From: Manoj Patel [REDACTED]
Sent: 03 January 2013 15:44
To: Janice Chapman
Cc: 'Manoj'; Sarah Burbridge
Subject: RE: Application for Discharge of Conditions PP-02300511 - AW/292/12/DOC
Attachments: Cond-3- updated 2 Jan 2013.doc

Ref: **AW/292/12/DOC**

Condition 3 Plan – planning application ref AW/129/12 – Updated 2/1/2013.

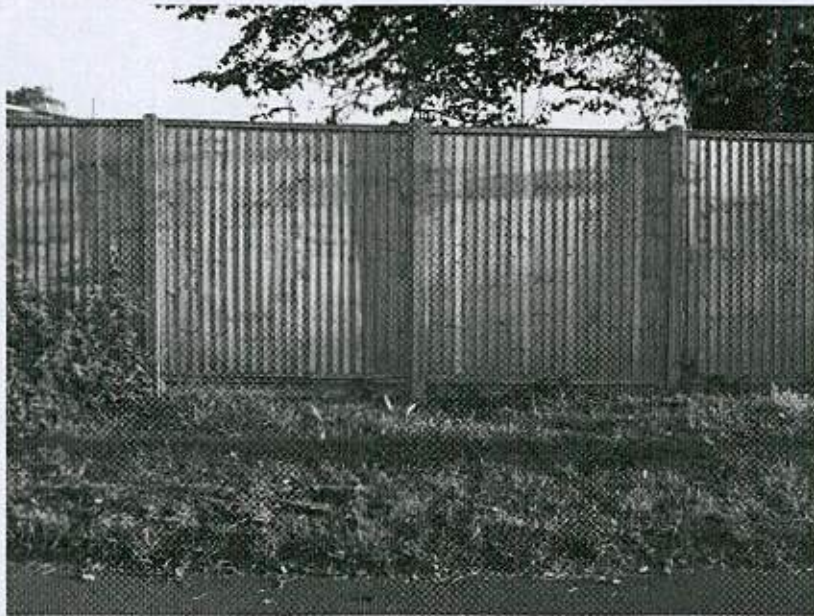
I have discussed the planting details as submitted with my team leader and these appear acceptable. However, a sample of the Dark Oak Preservative has not been submitted and I am of the opinion that this is too dark and would be of a harsh appearance. The neighbouring fence at No 36 which was recently approved is of a more natural finish and appearance. At this stage I would have to refuse the application but I am willing to hold the application open until we can reach an agreement.

Therefore I have updated the attached document to reflect that we will be using fencing that is similar in colour to that of No.36 and we will be using a clear preservative as indicated in the attachment to keep the fence in its natural colour.
